# memorandum

date June 8, 2017  
to Lauren Anderson, Planner; City of Mercer Island  
from Tobin Story, ESA Ecologist  
subject Hagstrom Review CAO17-004

ESA reviewed the following City-provided documents relating to the project: CAO17-004 SEPA Checklist (prepared by Brad Sturman, Sturman Architects), Hagstrom Residence: Watercourse Buffer Reduction Critical Area Study (The Watershed Company, 2017) and the Hagstrom Residence Site Plan (Sturman Architects 2017).

MITIGATION PLAN

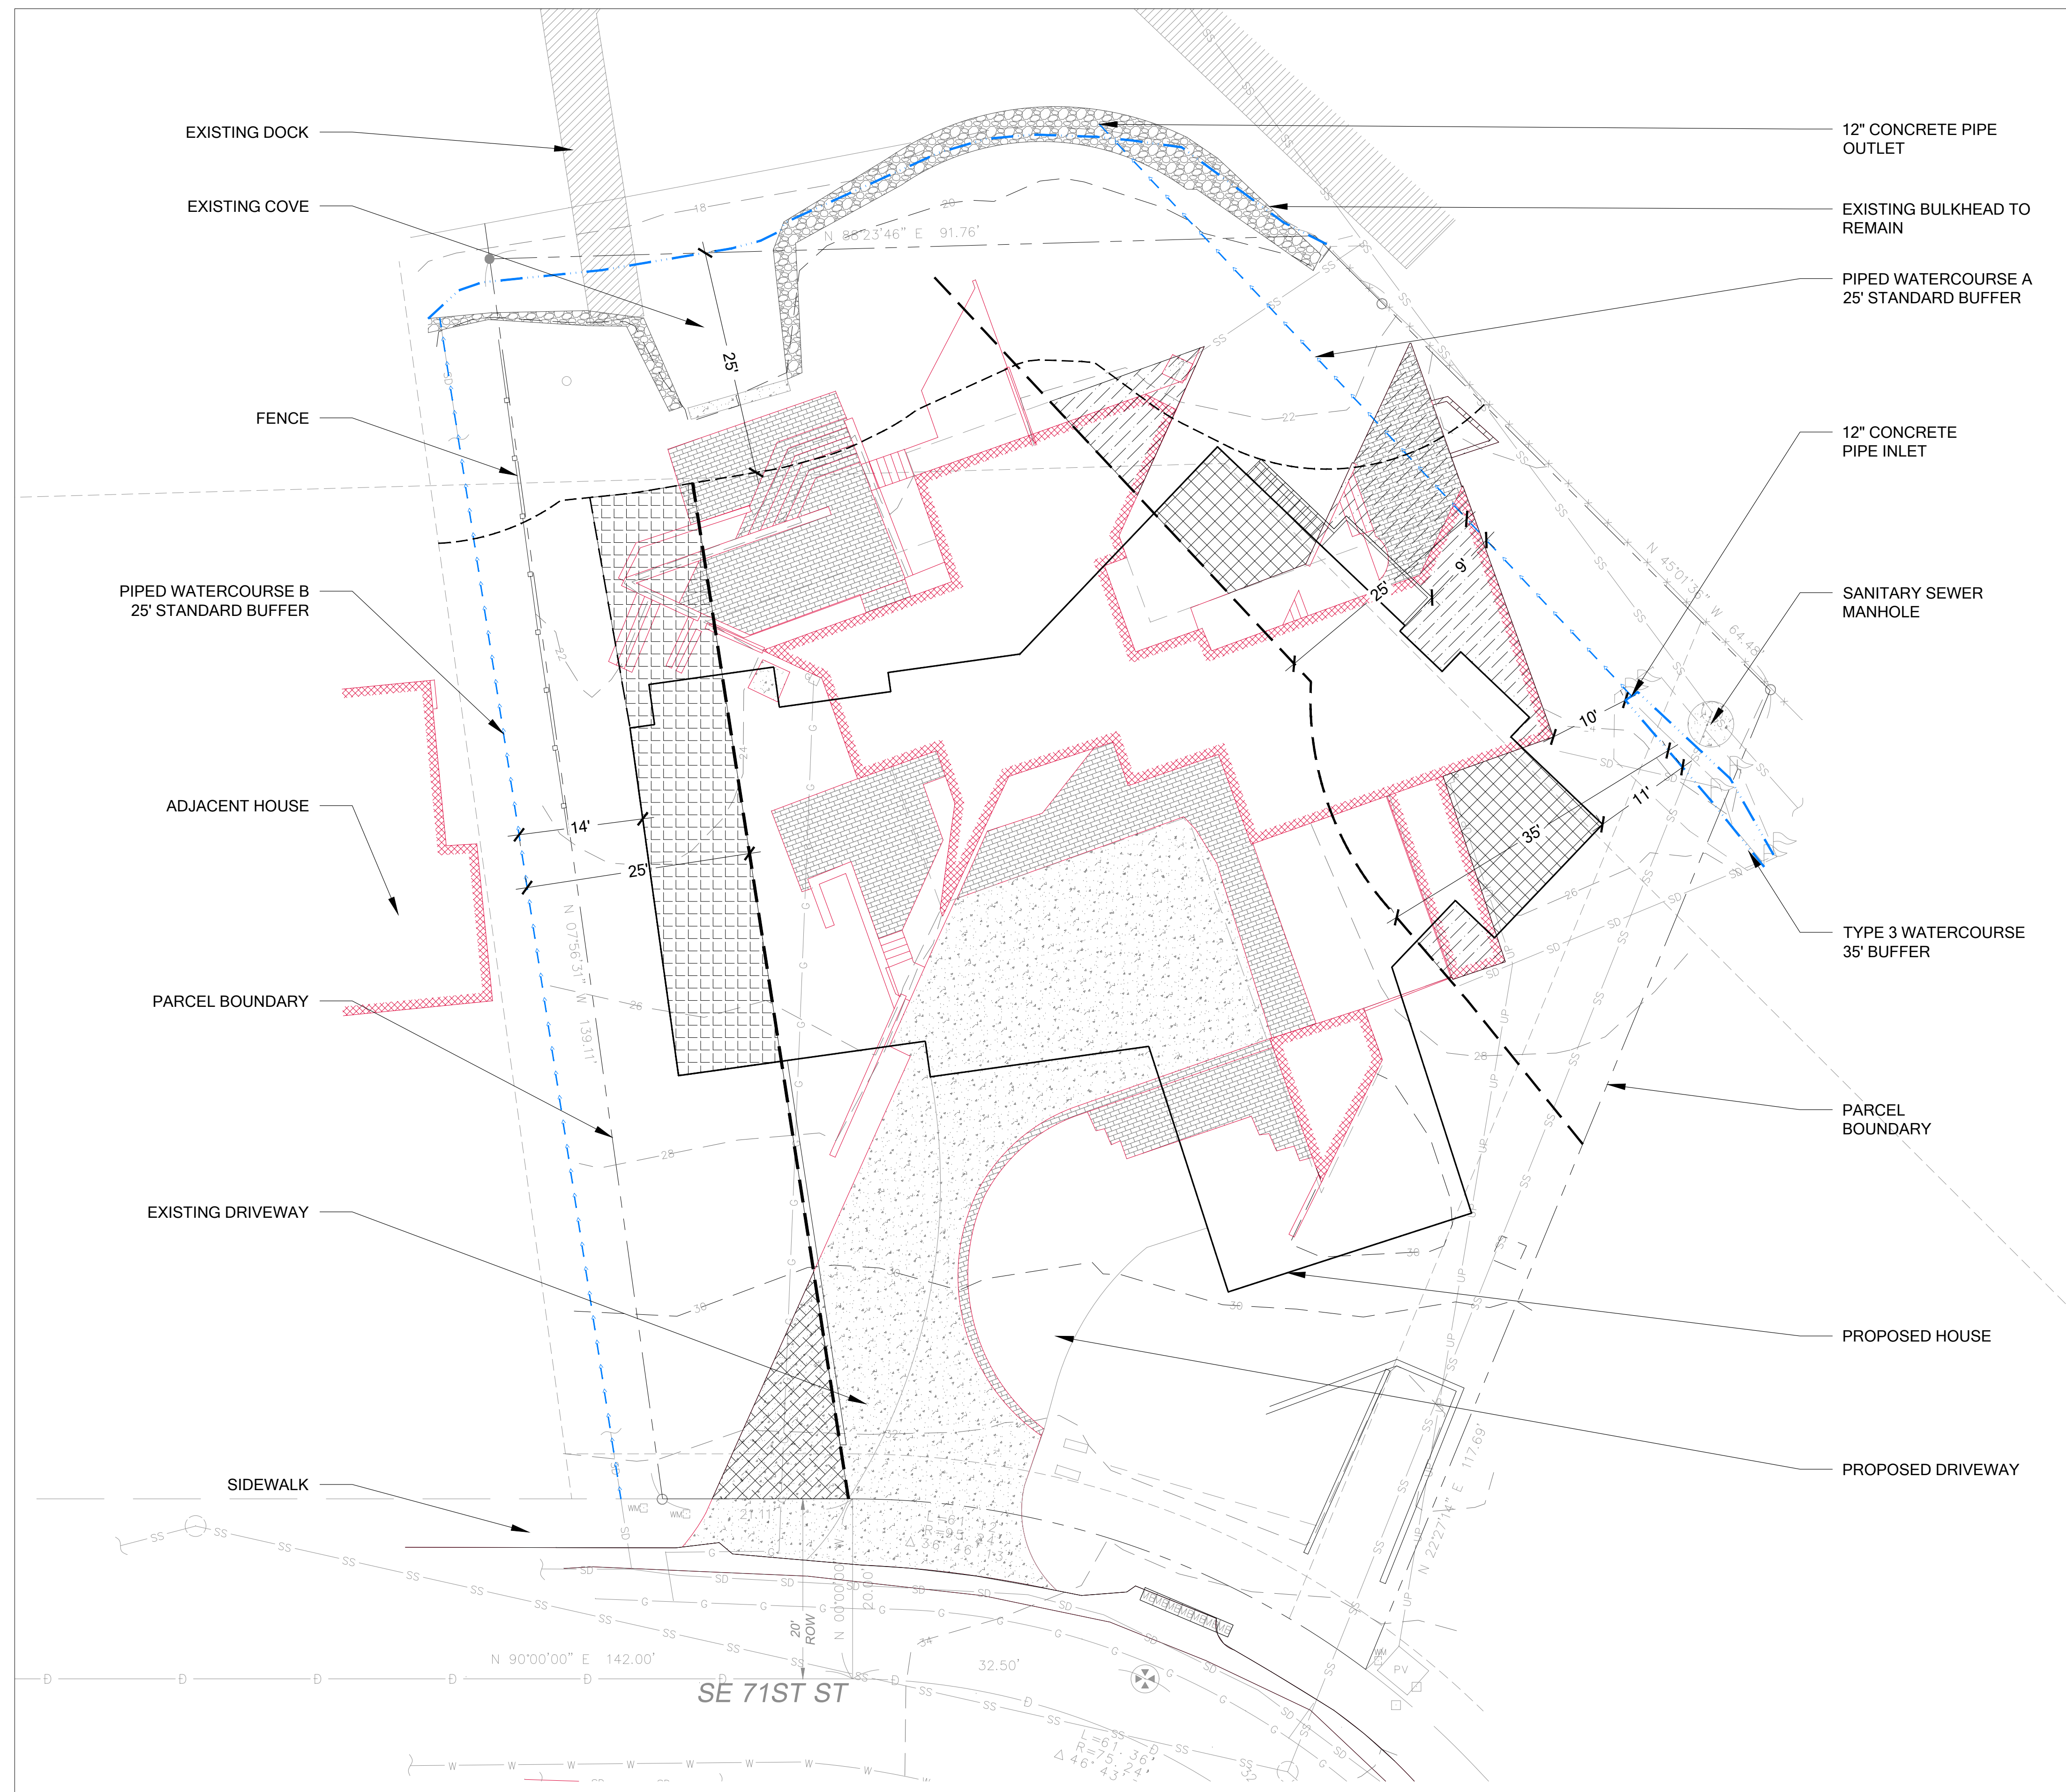
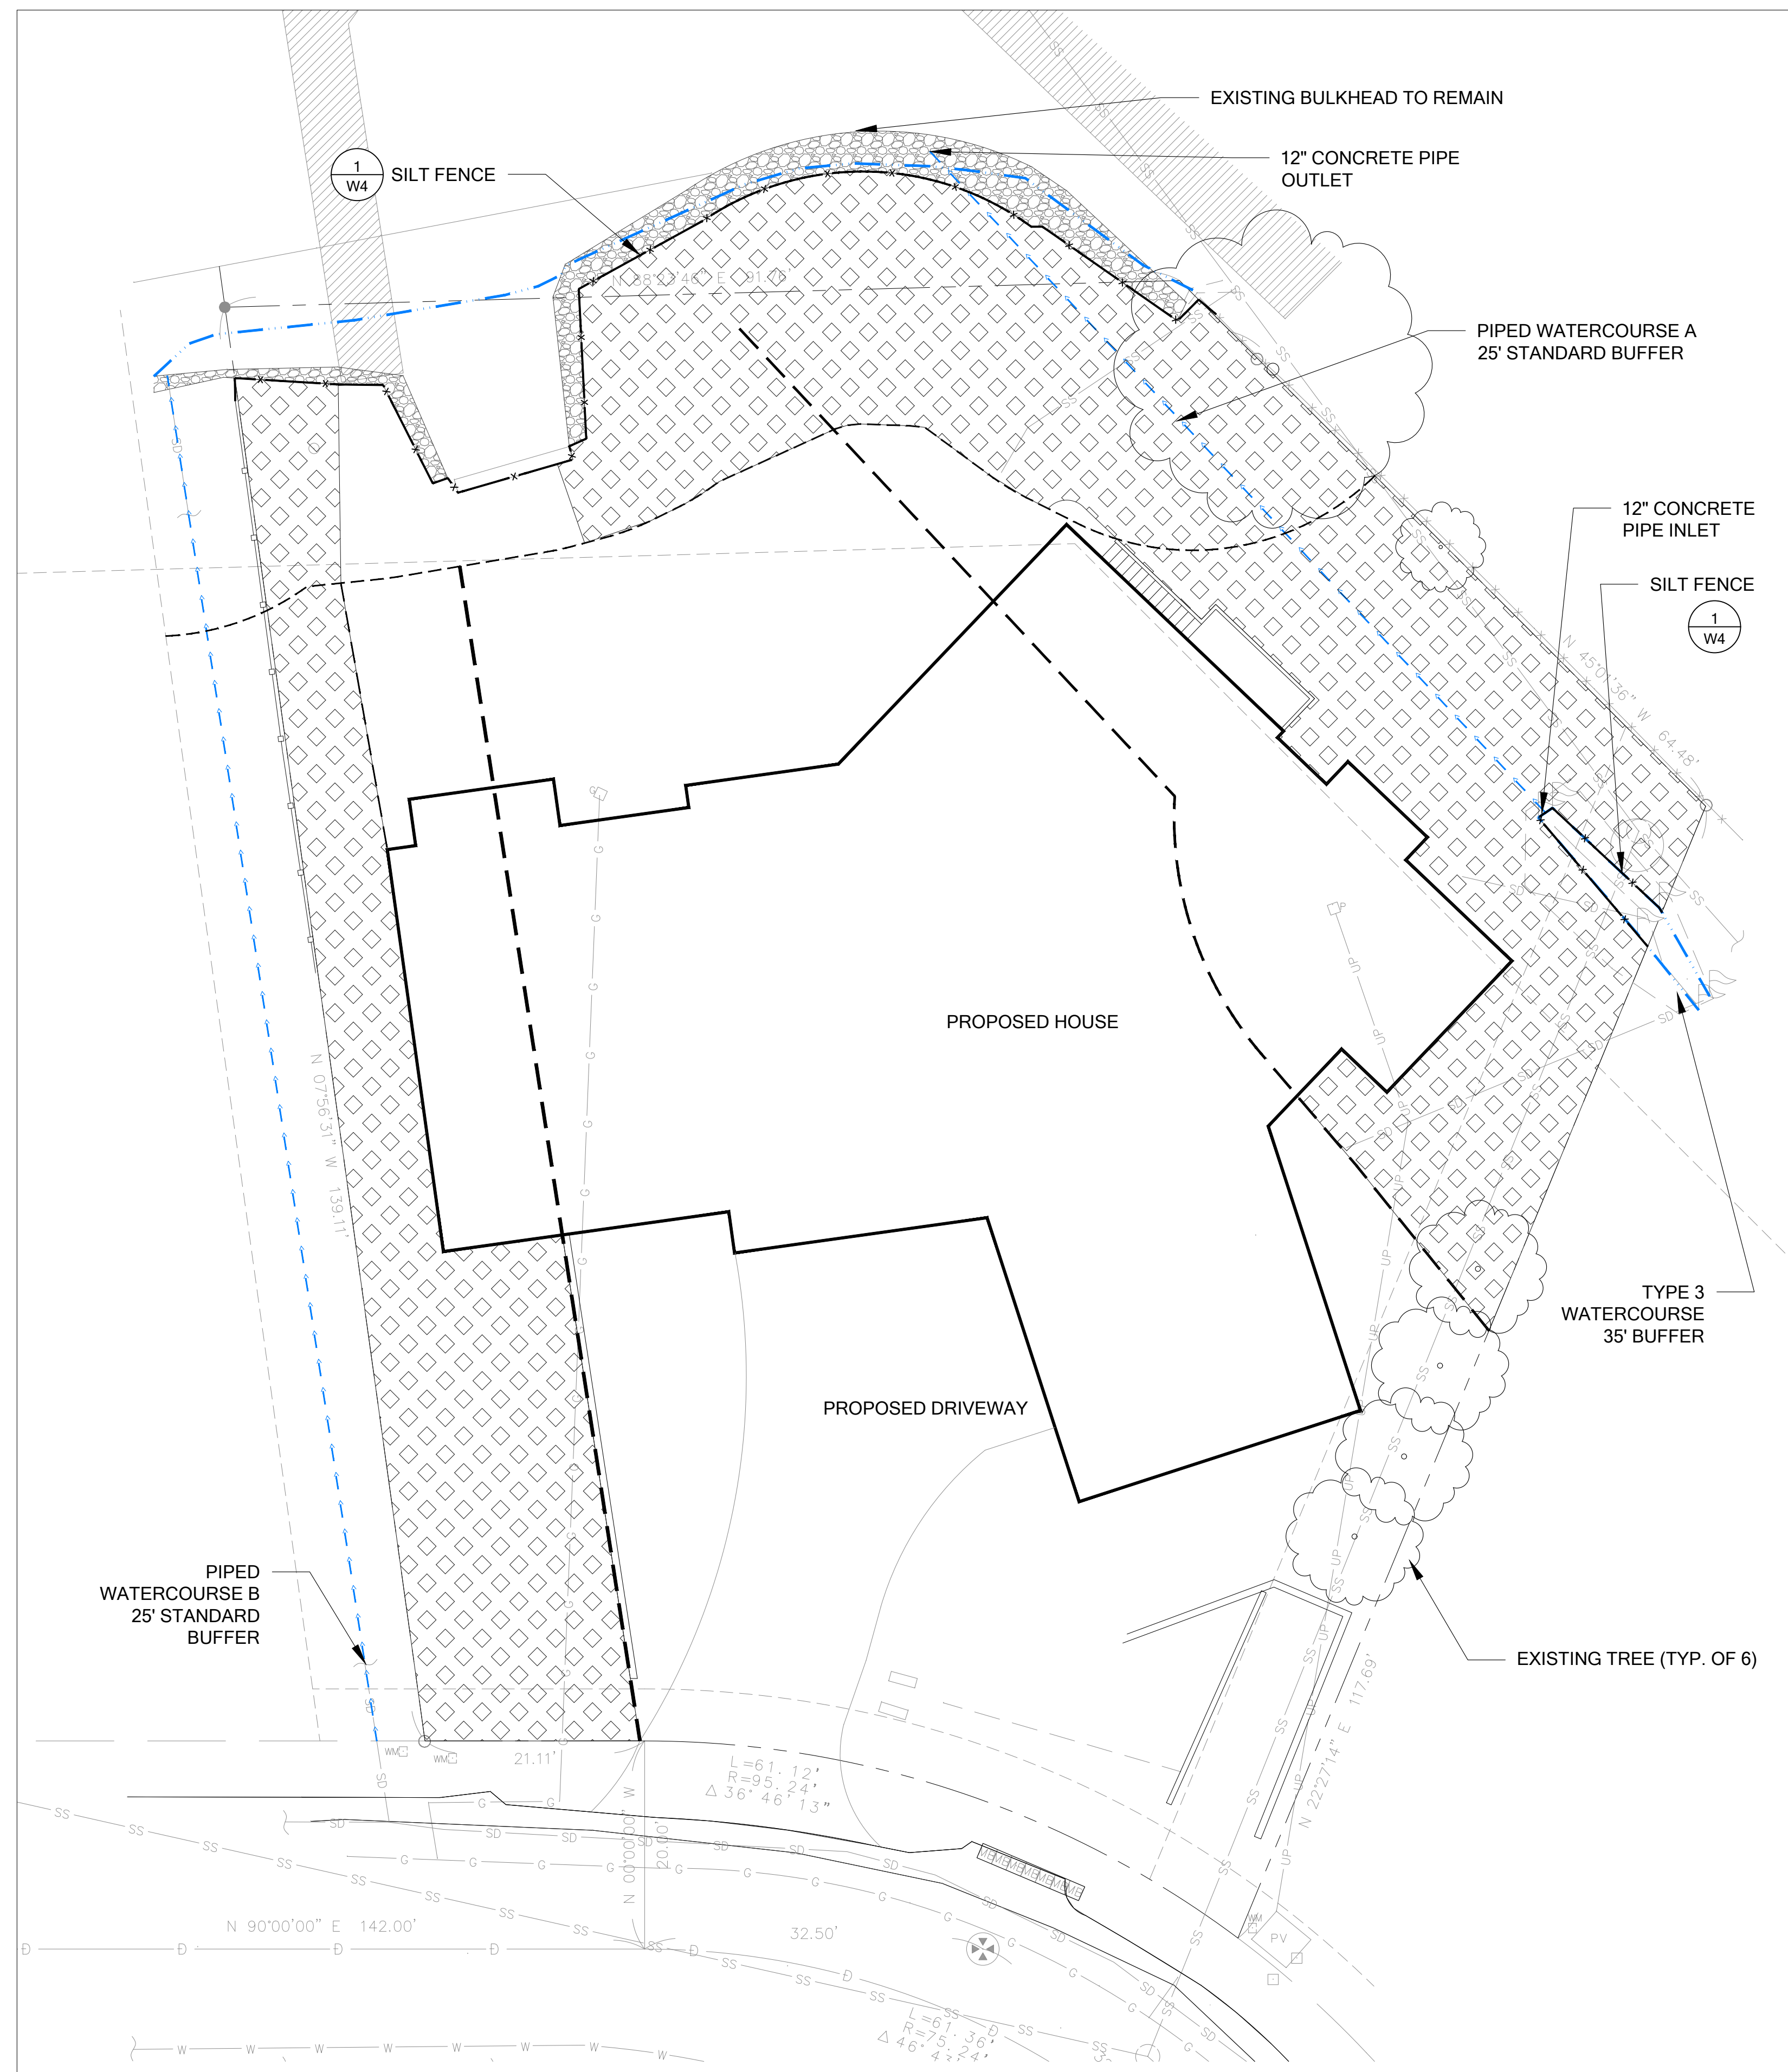
*Concern* - The study does not specifically delineate minimum buffers which will be maintained for the piped portion of Watercourse A. Specifically, a staircase is shown which appears to encroach within 3 feet of Watercourse A.

*Concern* - On sheet W3 of the drawing set the legend lists the buffer enhancement area for shoreline setback mitigation at 1,819 SF, but page 10 (section 5.0) of the critical area study lists that enhancement area at 1,908 SF.

On the “second” sheet W4 of the drawing set (assuming it is meant to be sheet W5) there are ten (10) shrubs listed in the planting schedule, but on page 14 of the critical area study (section 6.1) it states that “nine native small tree/shrub species and five native groundcover species are proposed in the mitigation area.”

Also on “second” sheet W4 hatched areas for groundcovers are shown beneath proposed shrub plantings. If the quantities listed for groundcovers in the planting schedule are calculated to be planted at 24” O.C. across the entirety of these hatched areas, this would result in too many plants being planted on the site. This could be mitigated if the quantities been adjusted to leave room for the other plants on the plan.

*Recommendation 3*– It is recommended that the study specifically list and indicate the minimum buffers for the piped portion of Watercourse A. MICC 19.07.070 allows for reduction of buffers around piped watercourses, but stipulates that the reduced area must be adequate to protect the watercourse. ESA’s primary recommendation is to consider daylighting Watercourse A (see Recommendation 1). If the applicant provides adequate documentation that portions of Watercourse A cannot be daylighted as part of the proposal, we recommend that the applicant consider opportunities to provide a 5-foot minimum buffer (free from new fill and structures) to the west of Watercourse A in order to preserve ecological buffer functions.. At a minimum, this should include realignment of the stairway on the east side of the proposed structure.

*Recommendation 4* – It is recommended that the study correct these inaccuracies for consistency, and clarify that the number and spacing of mitigation plantings is correct for the size of the mitigation area.
